Ref: SSD-94765473

State Significant Development Application

Mixed Use Development 32-42 Cooper Street, Strathfield

Figure 3: Building Section showing departure from Part 25m and Part 59m height of building control

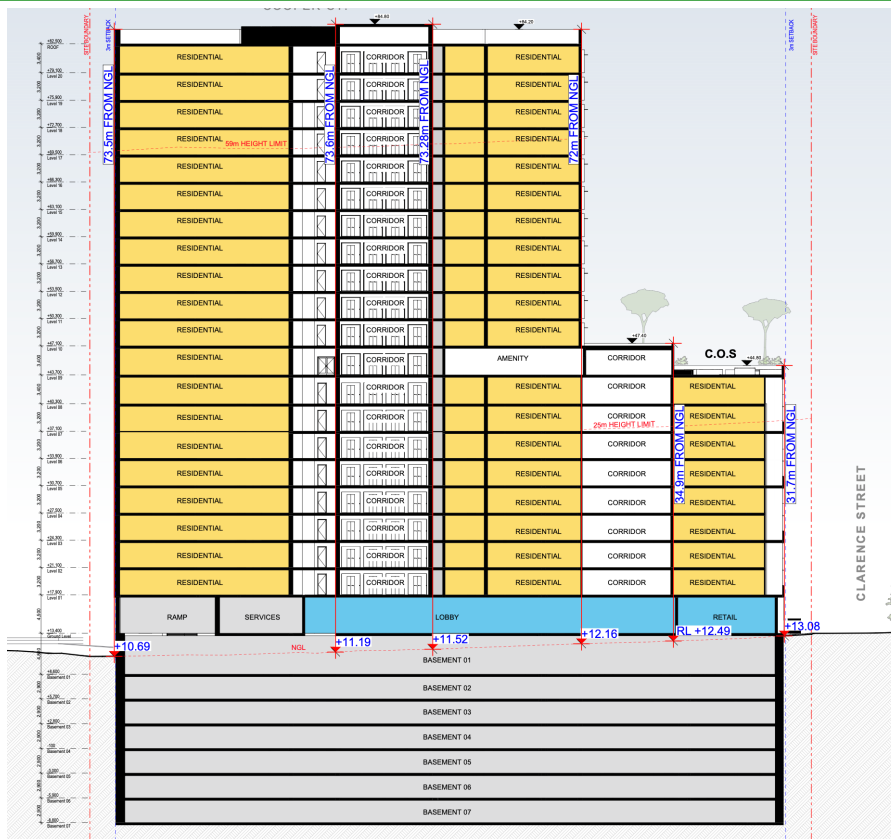
- Despite this, the development seeks a building height of approximately 74–75 m, depending on the document referenced, representing a variation of up to 25.7% above the 59 m standard and up to 30.4% above the 25 m standard. These proposed heights closely align with the TOD incentive height of 75 m, which is only intended to be available where full amalgamation and comprehensive infrastructure delivery are achieved. In addition, the proposal seeks an FSR of 6.95:1, which substantially exceeds both the base envelope controls and the maximum TOD bonus FSR of 4:1.

- Accordingly, the applicant has not demonstrated that compliance with the height standard is unreasonable or unnecessary, nor provided sufficient site-specific justification to support the contravention. The proposal therefore fails to satisfy Clause 4.6(3)(a) and (b) of the Canada Bay LEP 2013 and is inconsistent with the strategic intent of the Homebush TOD planning controls.

- The SSDA be amended to reduce height and floor space ratio consistent with the Canada Bay LEP 2013, such that:

- Part 9, Division 2 is not engaged (this would reduce the tower by at least 4 storeys and the podium by at least 2 storeys); and
- Any land dedication (including the 3.0m Cooper Street widening) may legitimately be considered for offset against contributions under the applicable contributions plan.
